DCO Hearing ISH1 on draft DCO, Tuesday 27 September

re: Requirement 20 – Decommissioning & Restoration

DCO Hearing ISH2 on Environmental Matters on Thursday 29 September

ELAF submissions re permissive paths / greenway, Access for All and Public Rights of Way (PROWs)

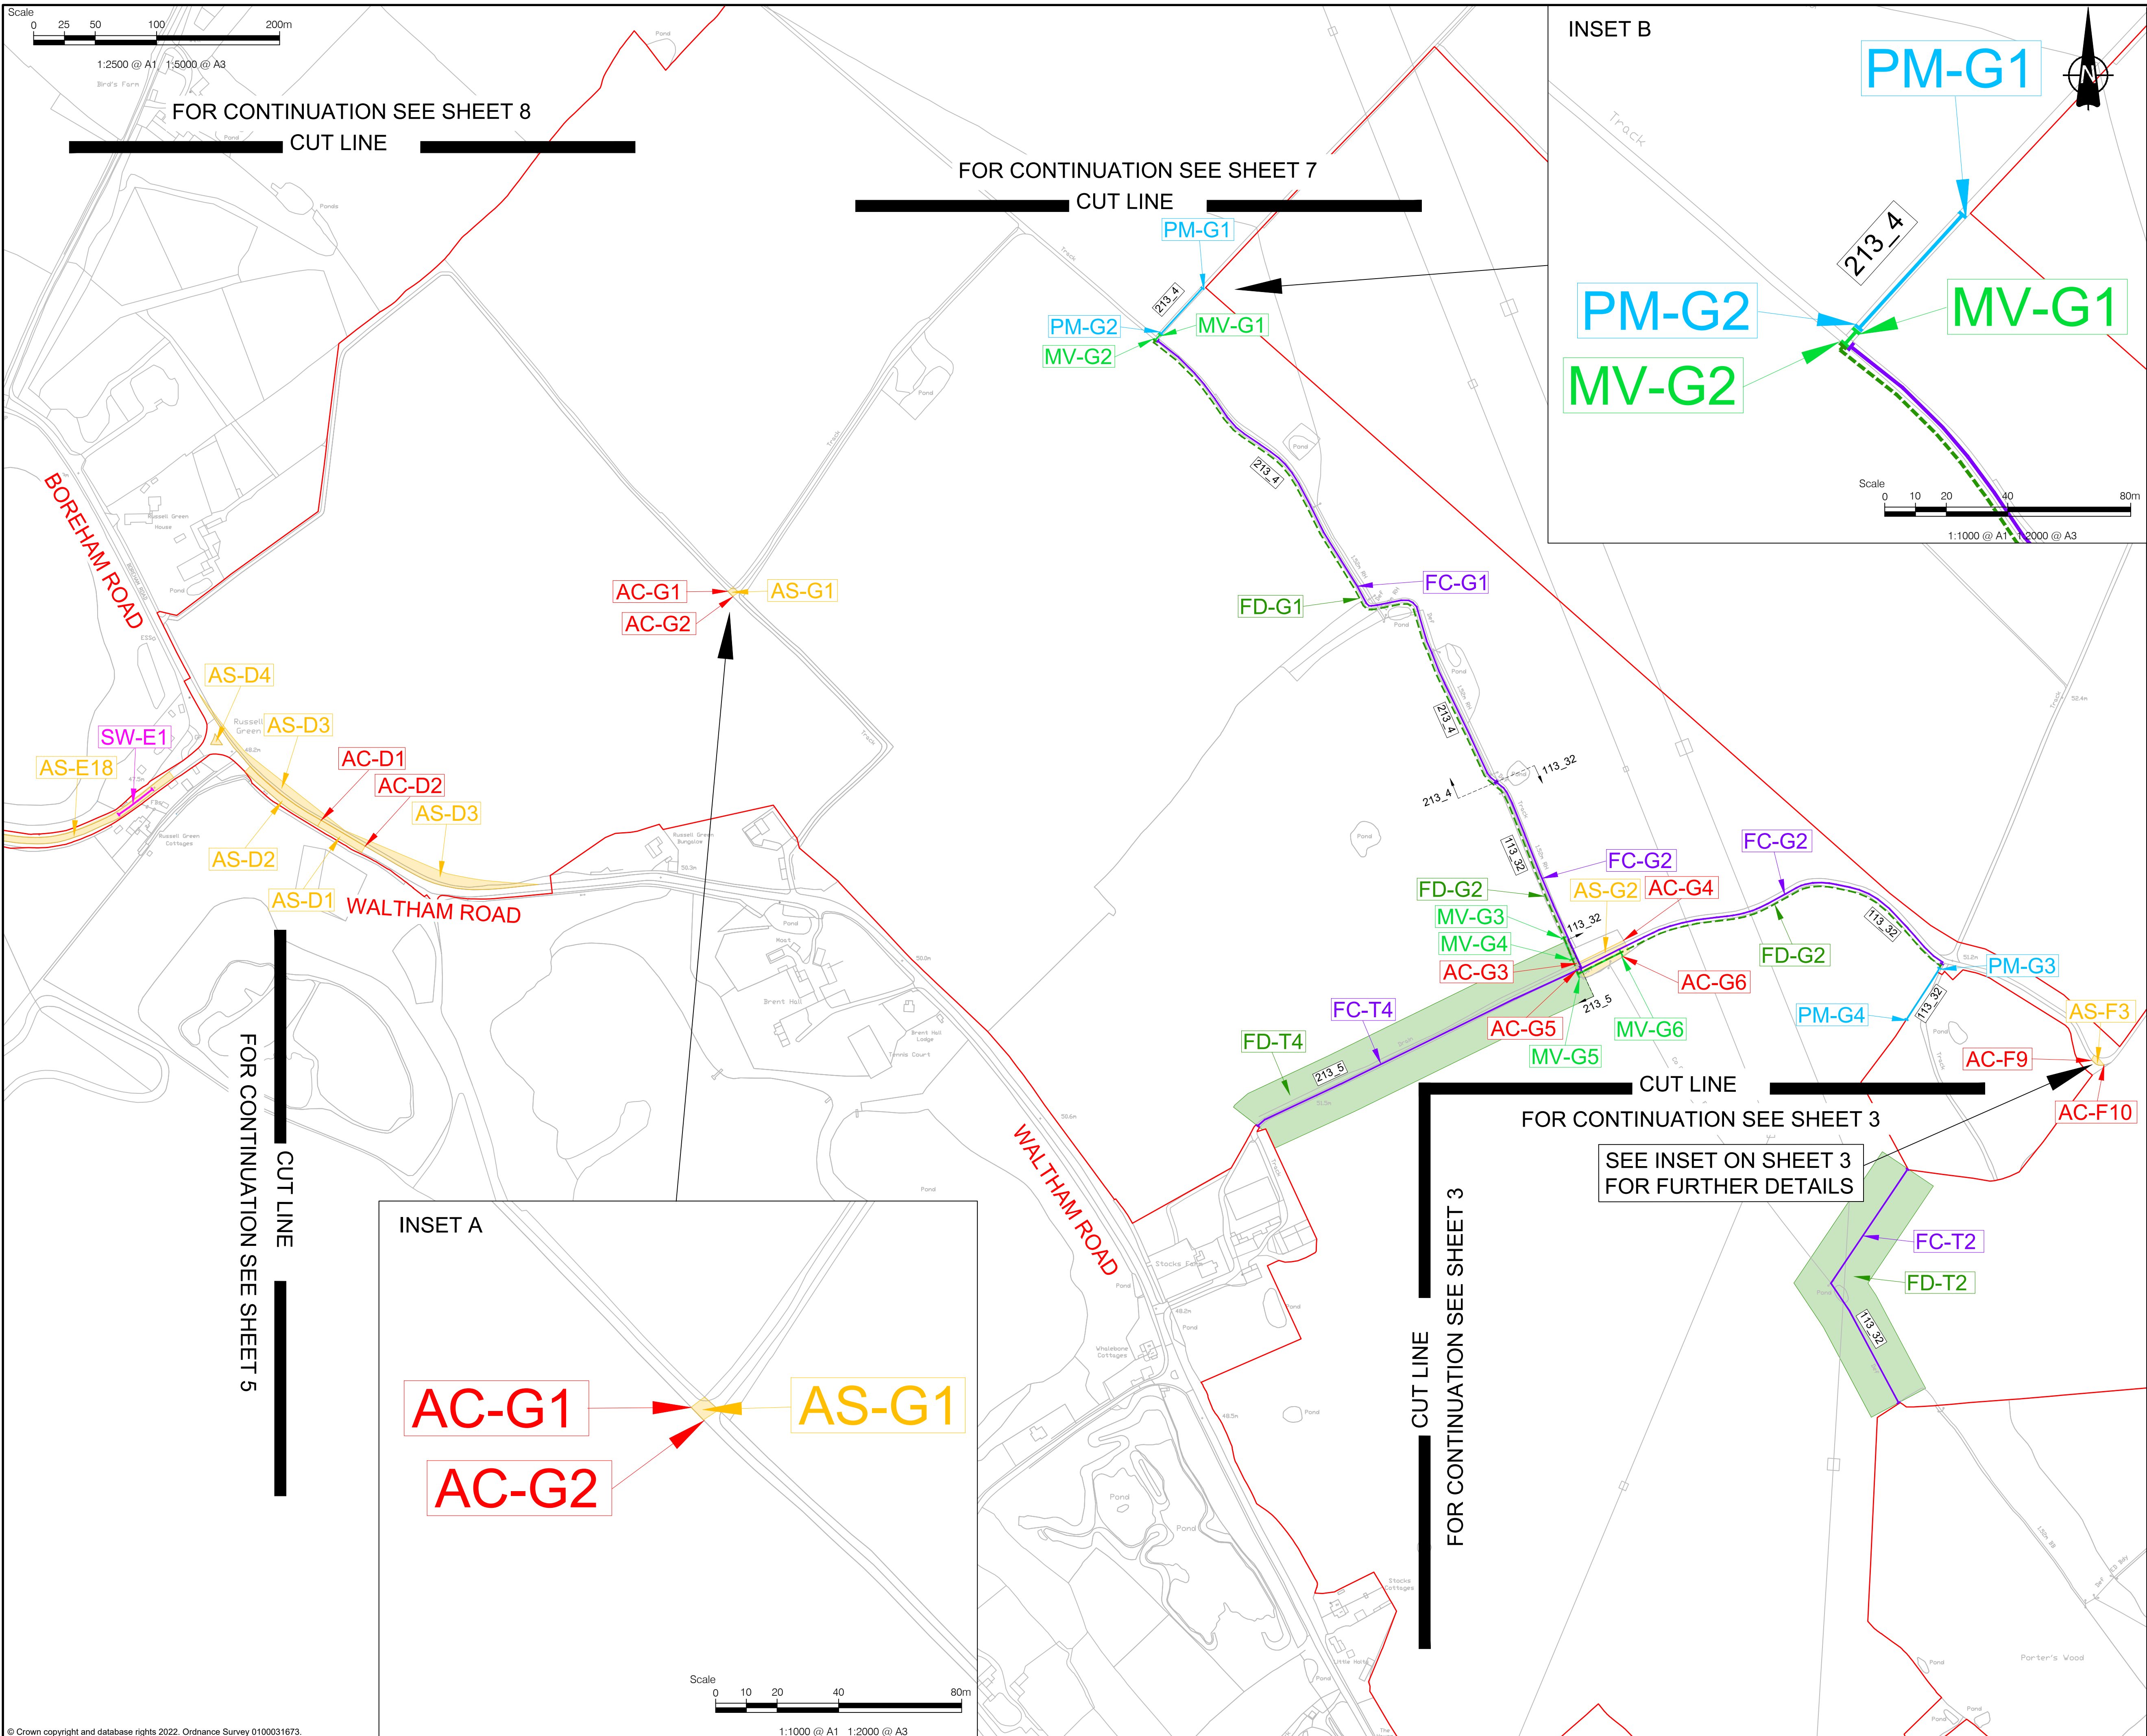
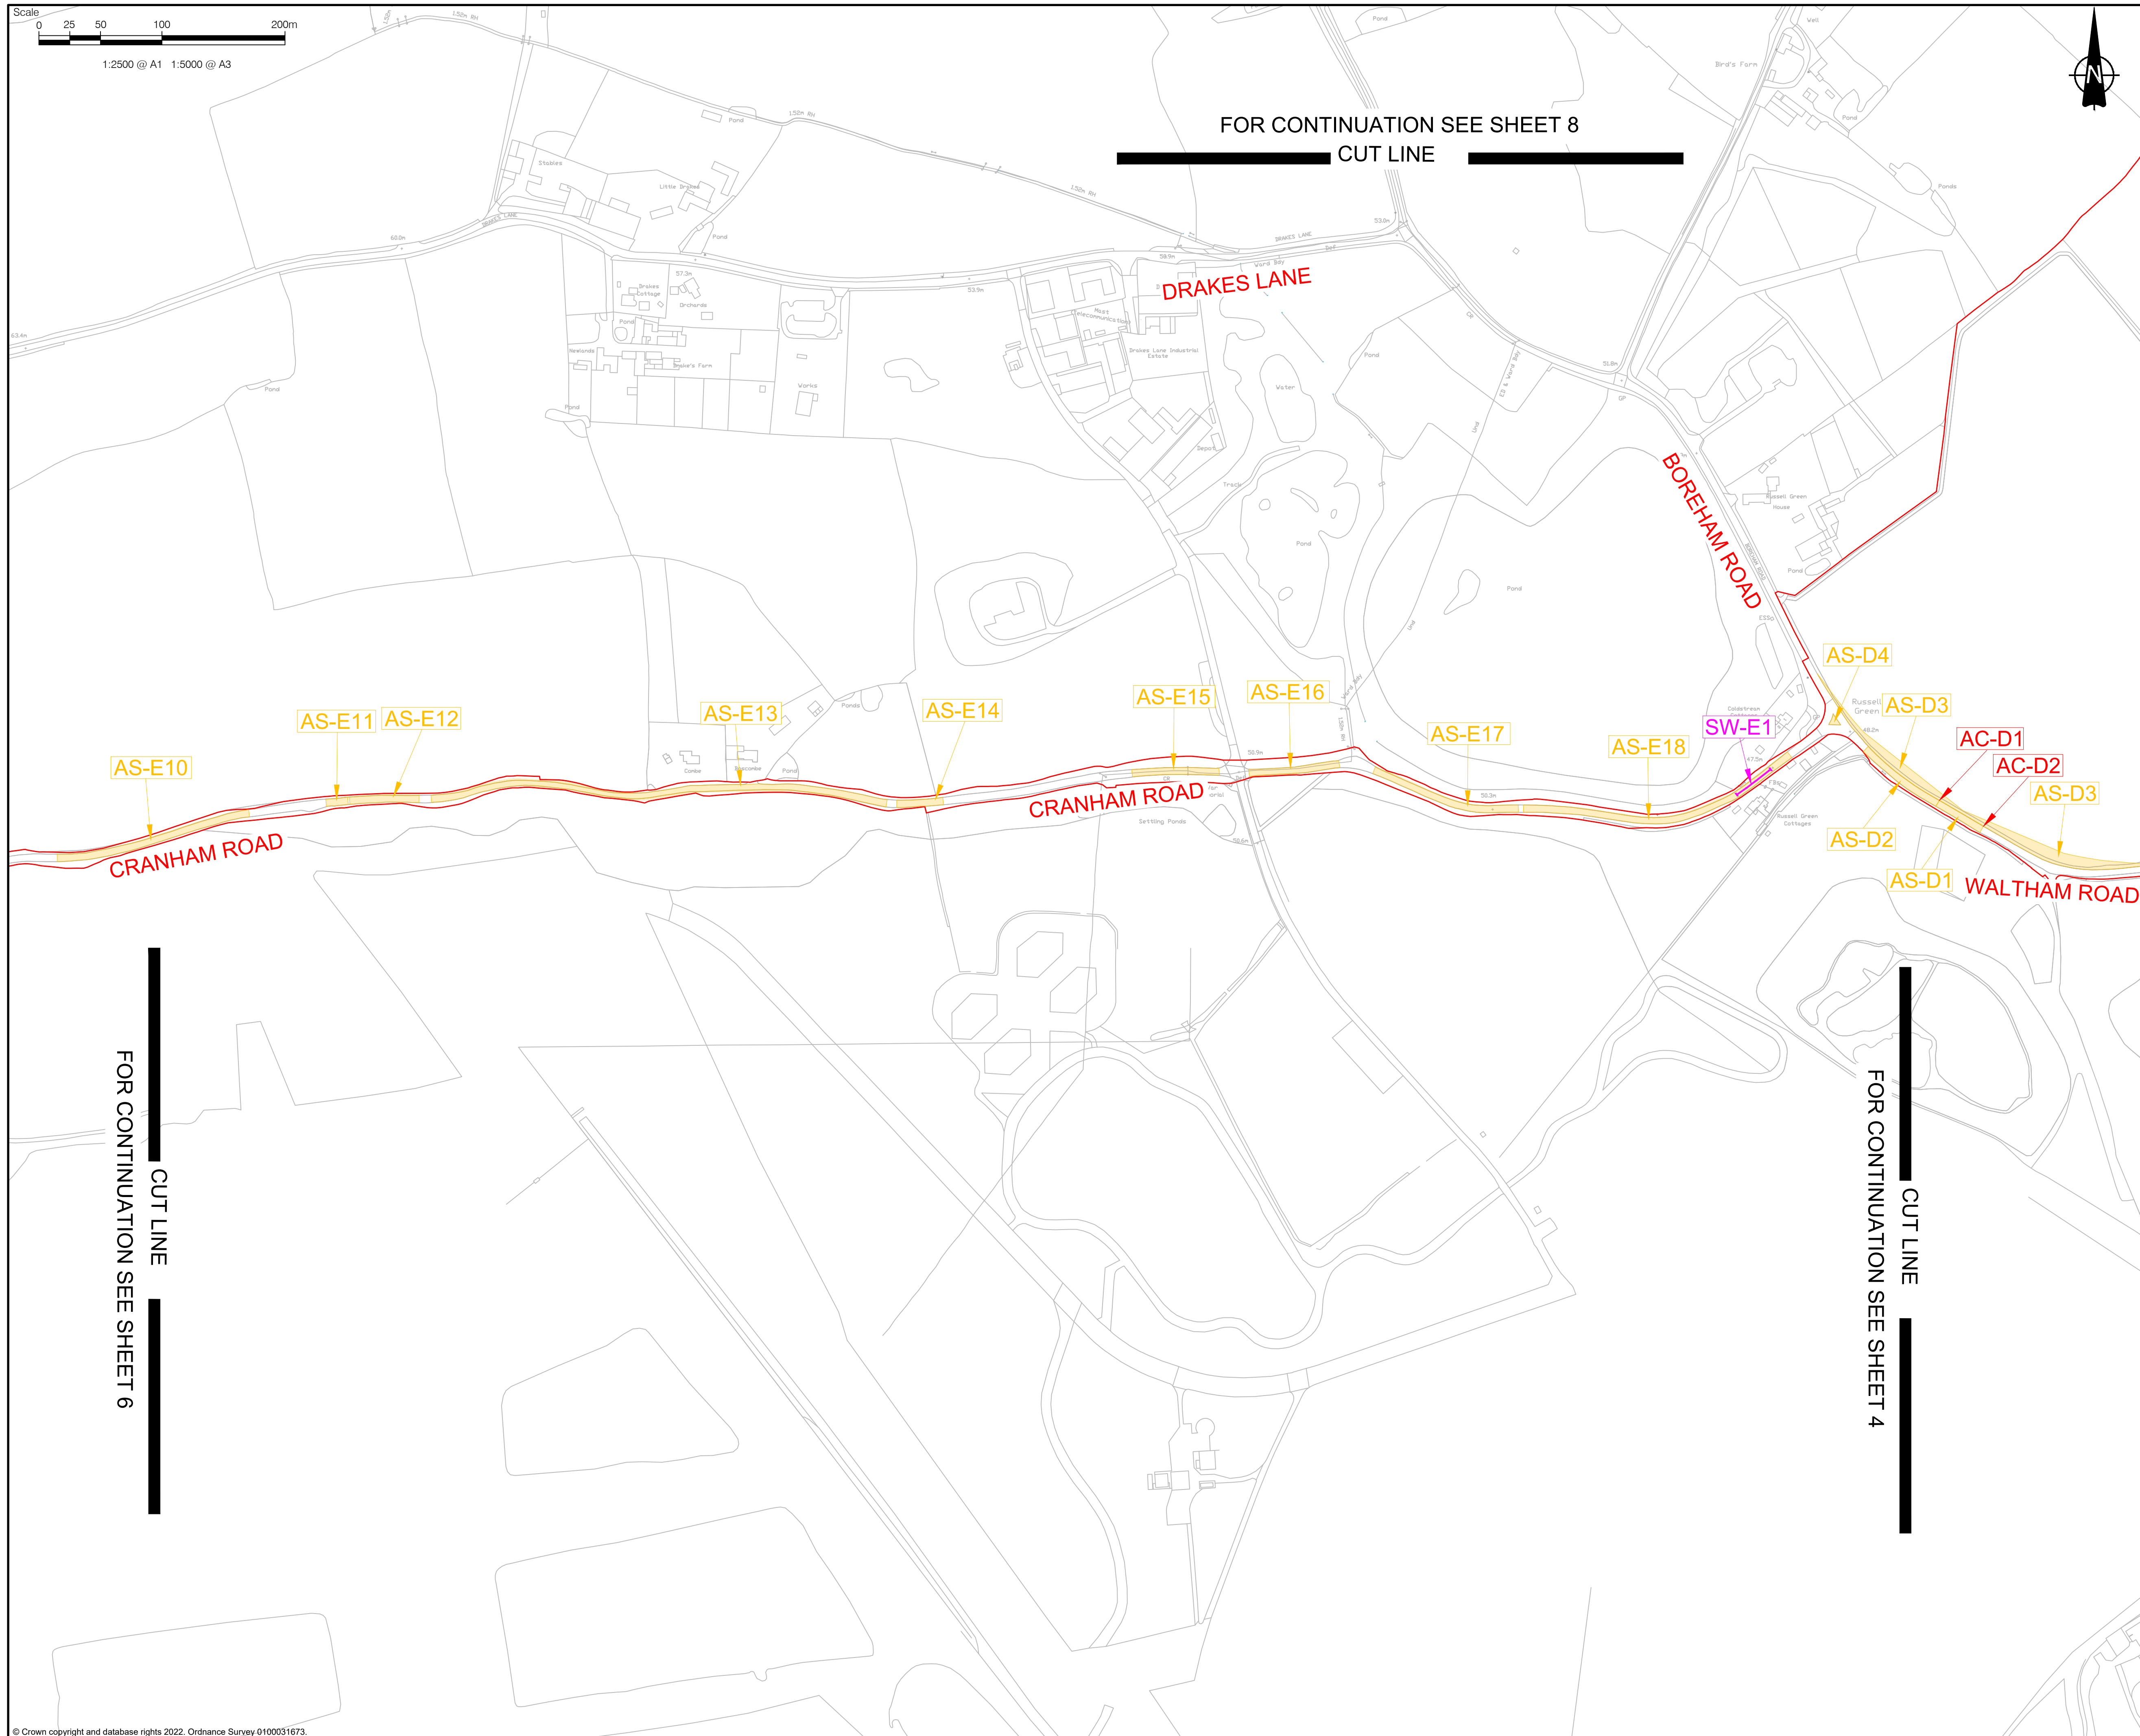
- (3) The permissive paths plan does not actually show the vehicular access routes. However, when looking at the Streets (and Access and Rights of Way) plans a lot of the permissive paths appear to be on the same line as the vehicular access tracks. The applicant said that the paths would be separated from the vehicular tracks during construction for health and safety purposes.
ELAF also noted that where a permissive path runs alongside or very close to vehicular access routes, it is not clear what the width of the permissive path will be, what the nature of the surface will be or whether there will be any vegetation or anything on either side of the path. Reference was made to Examination Library Reference document REP2_029 which was the applicant's written response of September to submissions made, including ELAF's submission (page 72 onwards). Mrs Evans of ELAF apologised for being unaware of this document.

(3) ELAF are concerned about the surface of the public rights of way which are going to be dug up to have cables run underneath them – labelled FC and coloured purple on the Streets (and Access and Rights of Way) Plans and listed in Schedules in the Order. Do the cables have to go under the public rights of way? Could they not go alongside or somewhere else inside the solar farm fencing? The digging up is not just for short lengths across a public right of way but sometimes also for 300 or 400 metres along a public right of way. The applicant said that the public rights of way will be reinstated to the same condition afterwards – as far as is possible / practicable.

The applicant confirmed that these PROWs will be closed for short periods during construction in a rolling programme whilst the cables are installed and the land is restored and so no diversions are justified / considered to be needed.
